RE: Graythwaite Rehabilitation Centre

In response to submissions

Yours faithfully,
nettletontribe

01 SHADOWS EQUINOX-9AM
-
NTS

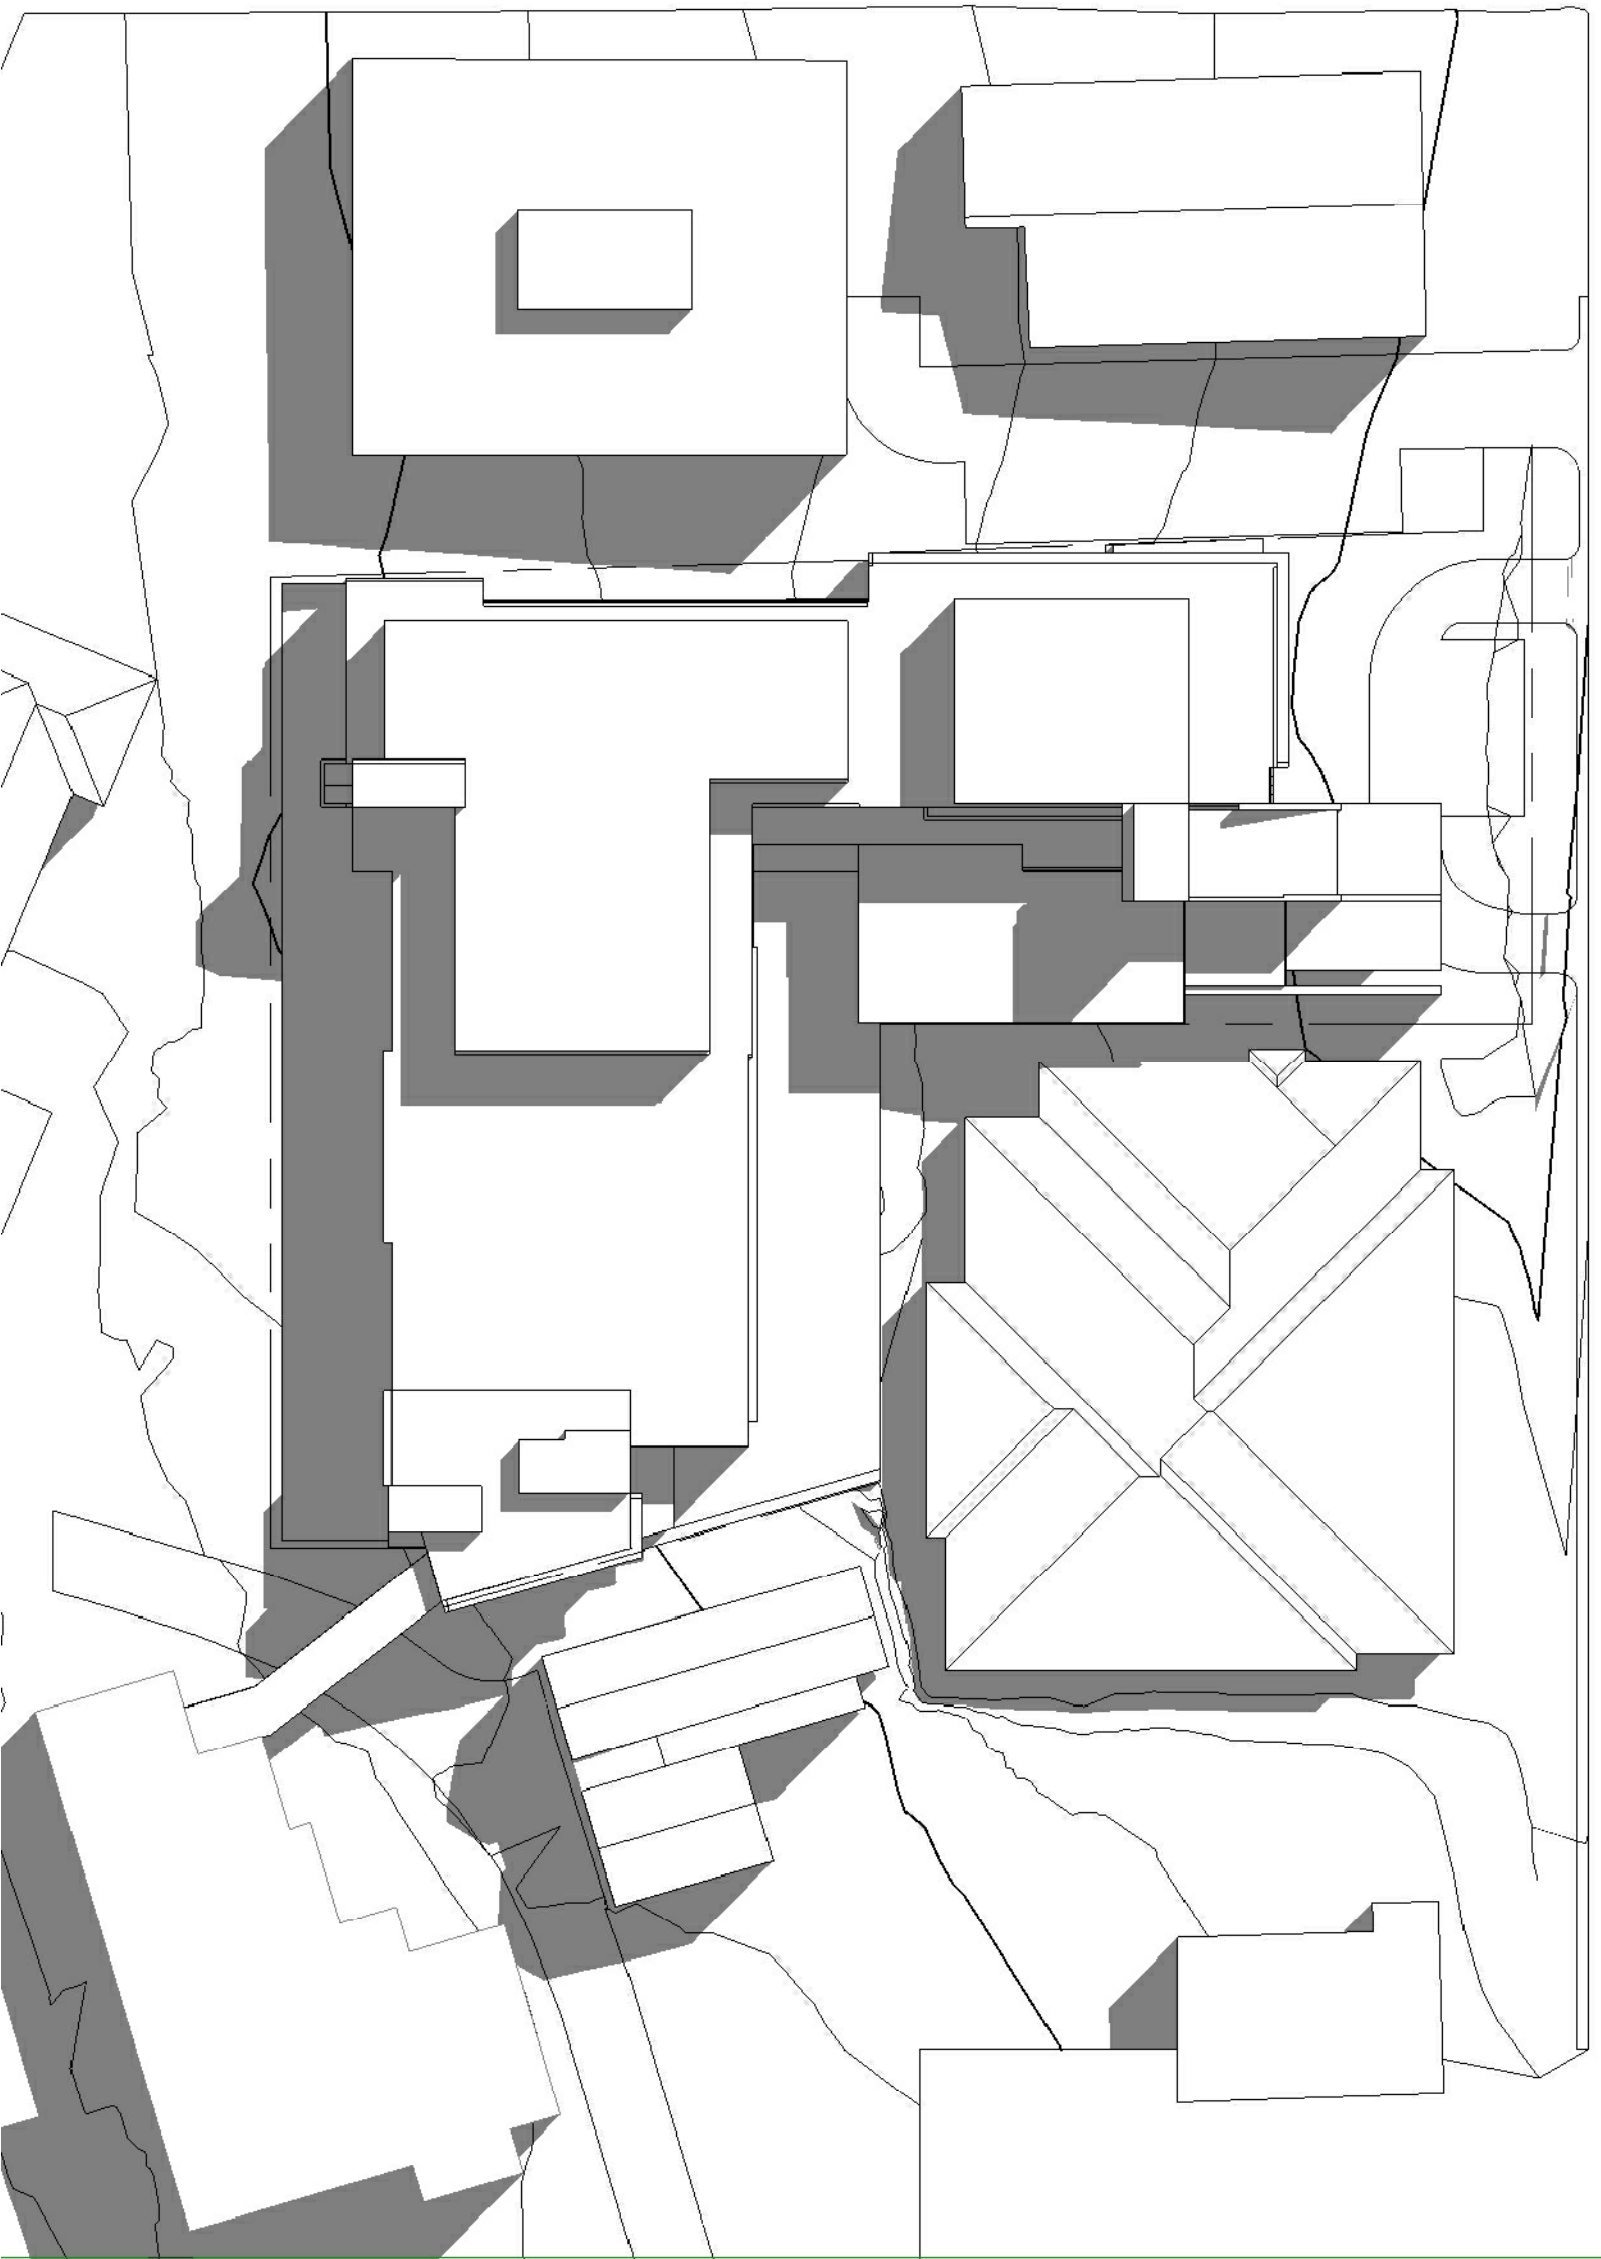
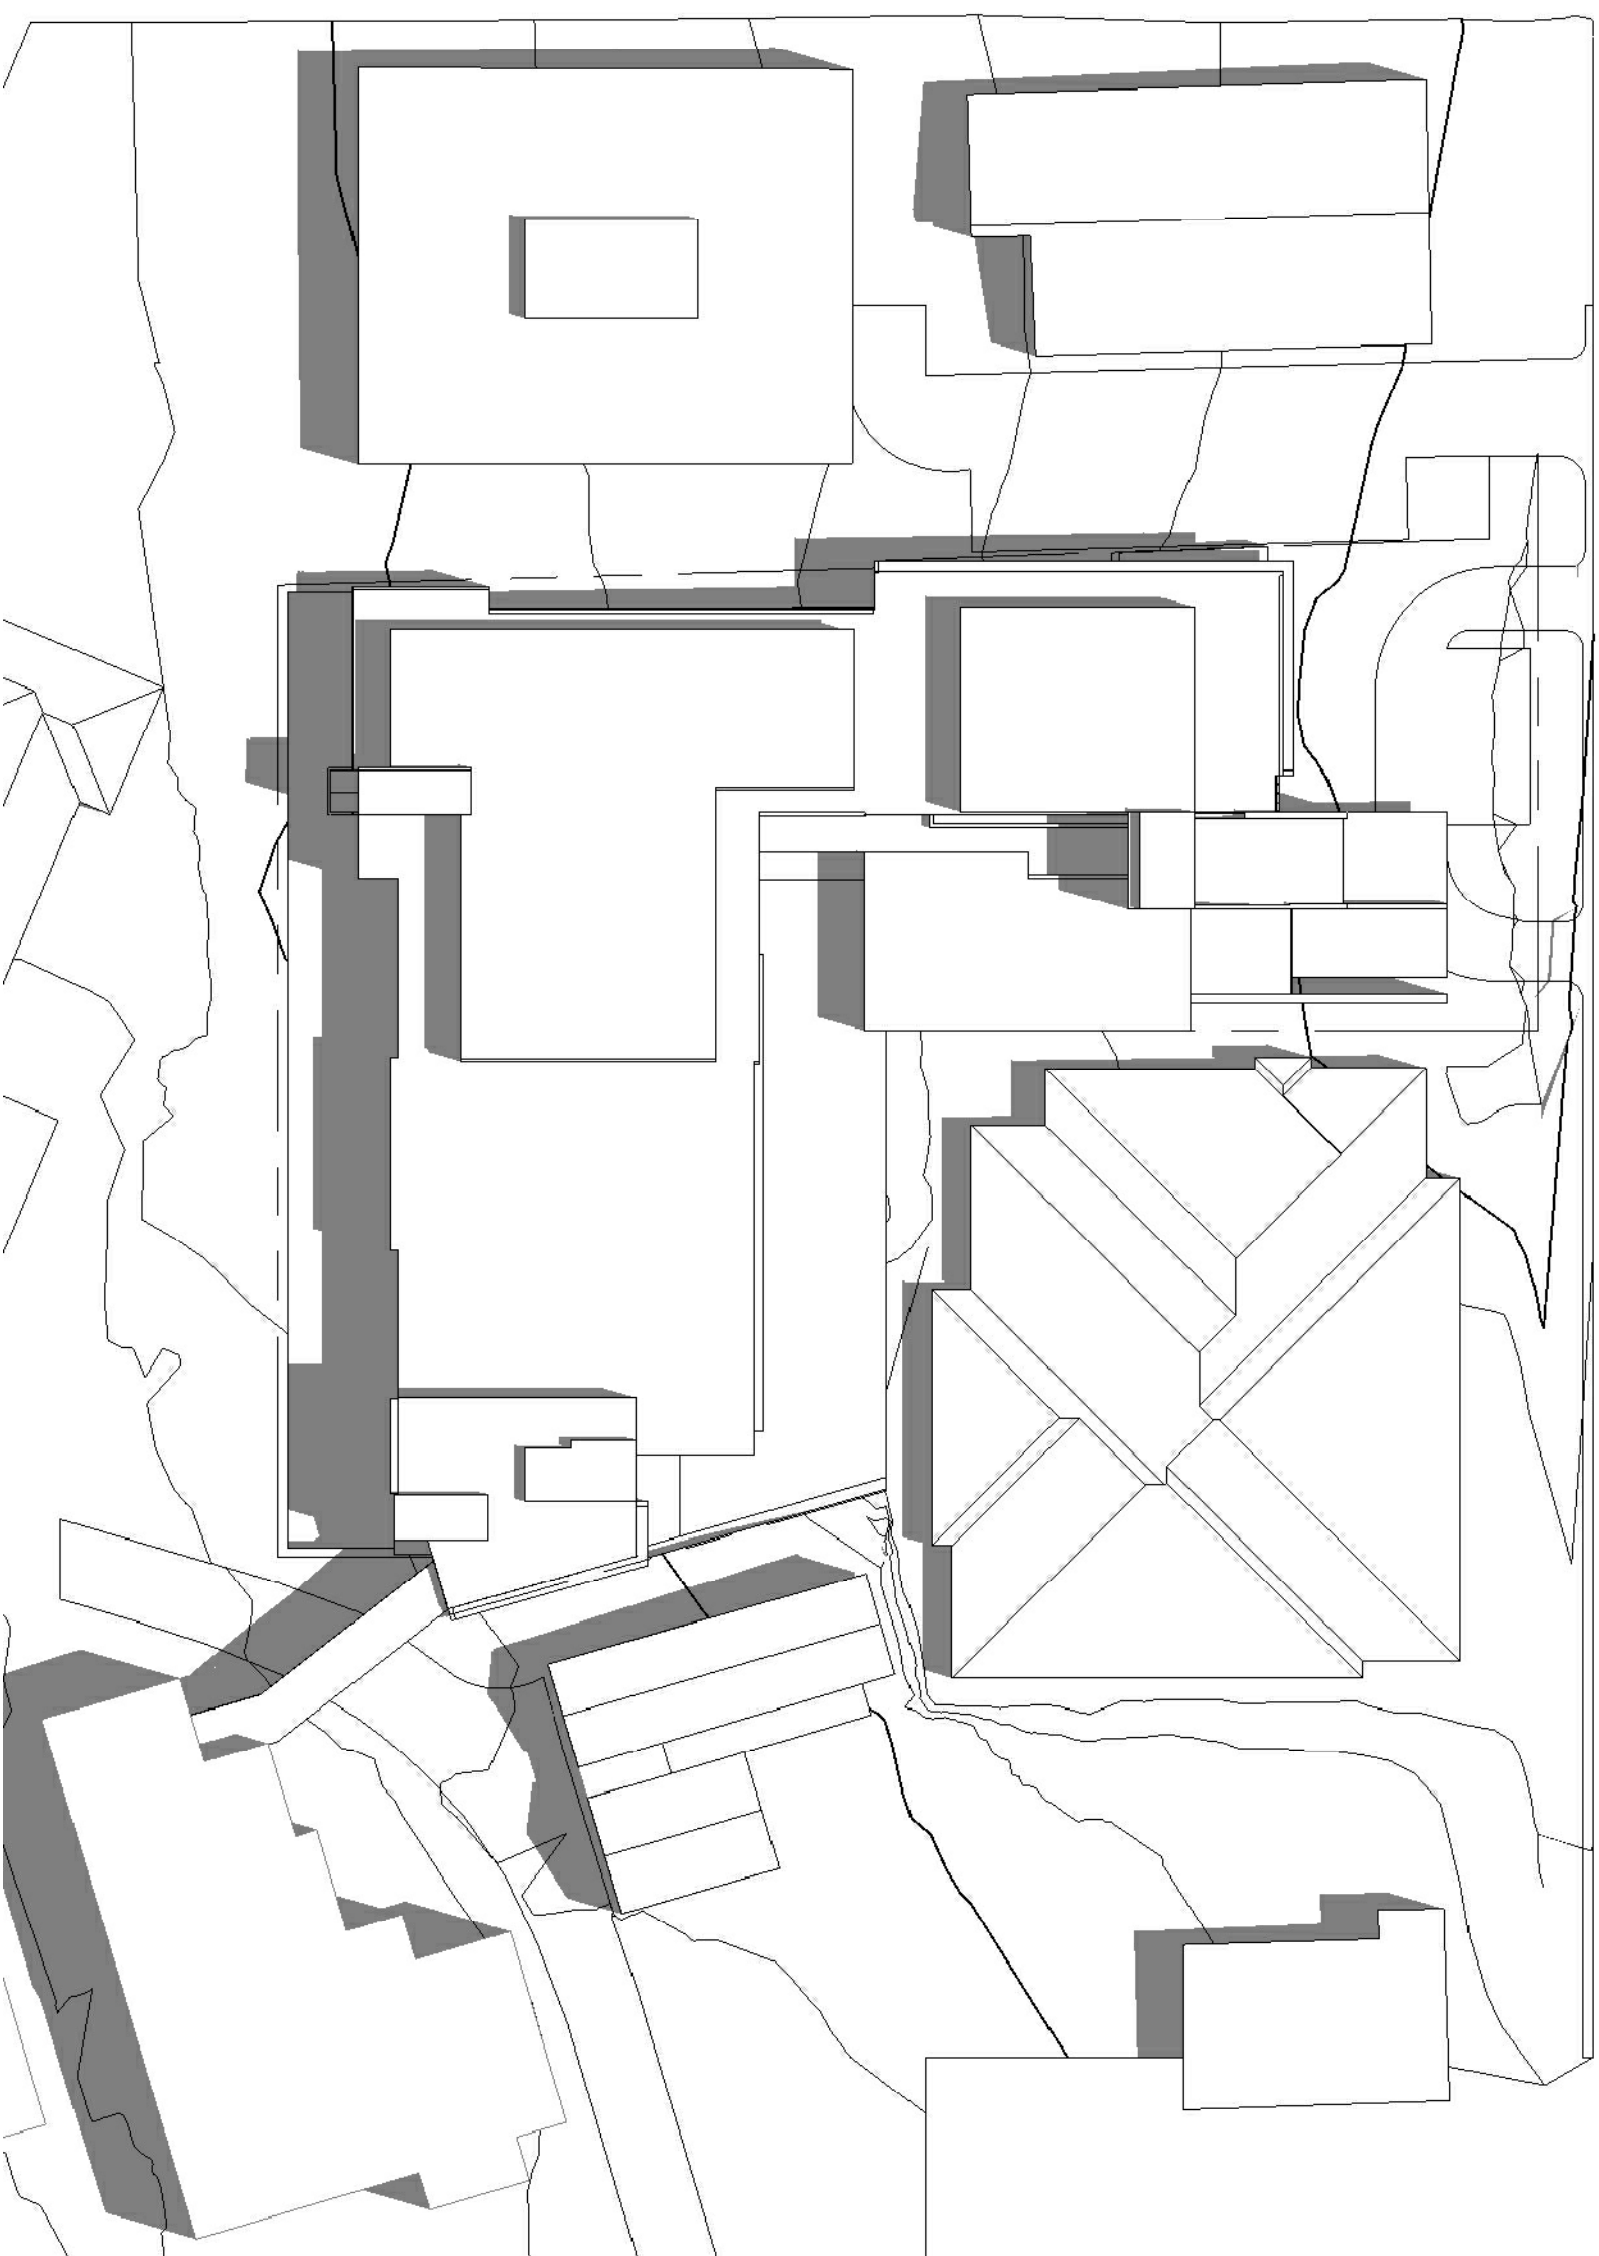
"Reducing the height would lessen the impact on Fourth Ave, residential streetscape and overshadowing of adjoining buildings to the west and Denistone House to the South."

No residential lands are overshadowed by the proposal.

The medical centres to the west of the proposed building are commercial in nature. The increase in morning overshadowing in winter is minor with good solar access for the remaining of the year.

There is no additional overshadowing to Denistone House which is presently overshadowed by the Trigg building which is some 2 storeys higher than the proposed building.

01 NORTH ELEVATION
SCALE 1:200

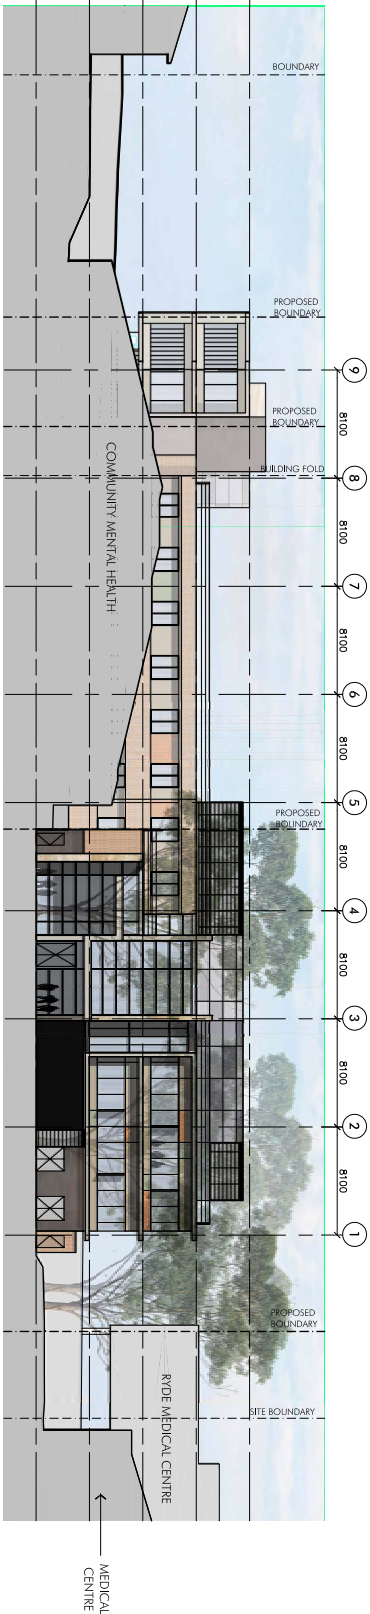
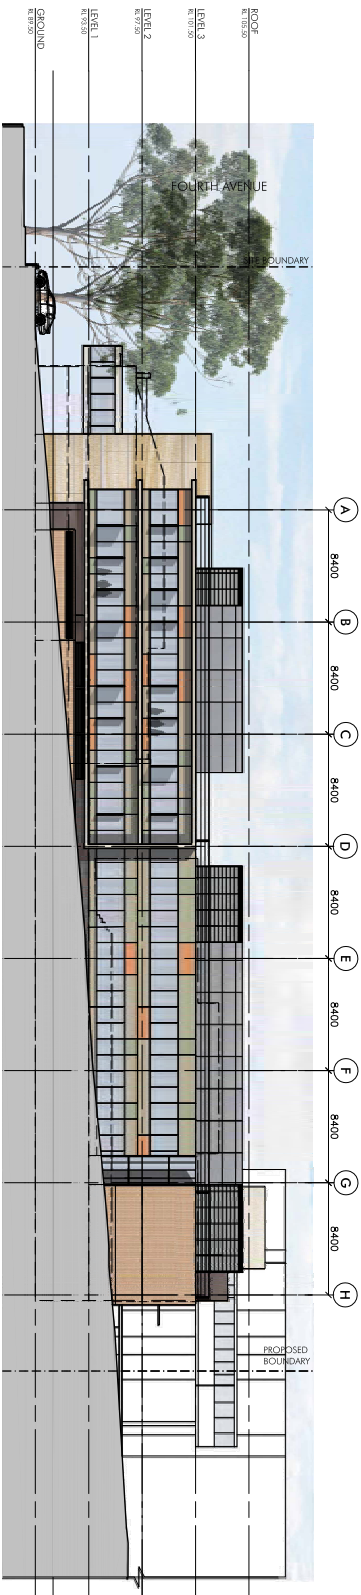
"4 Storey Massing" and "Relationship with surrounding single and two storey dwellings/low density residential development"

The context of the Ryde Hospital site and its adjacent neighbours, ie the Ryde Medical Centre forms part of the establishment of the bulk and scale of the Graythwaite Rehabilitation Centre. The historic use of the site in general has seen larger scale buildings there for many decades sitting in the context of the surrounding single and two storey dwellings/low density residential development.

The proposed Graythwaite Rehabilitation Centre is setback some 13.5-16.5m. This is a significant increase from the existing buildings and is purposeful to reduce the impact of the new building.

The new building flanked on the Fourth Ave frontage by the Ryde Hospital's Community Mental Health building and a Medical Centre building both of which are 1-2 storeys in height. These buildings are set back from the street boundary some 5-7m.

The proposed awning and entry wall of the proposed building is setback in line with the adjacent buildings and is at the same scale as these adjacent buildings. The siting and setback of the higher element stepping from the awning up to the main parapet and increase the setback relieves the impact of the increase in scale.
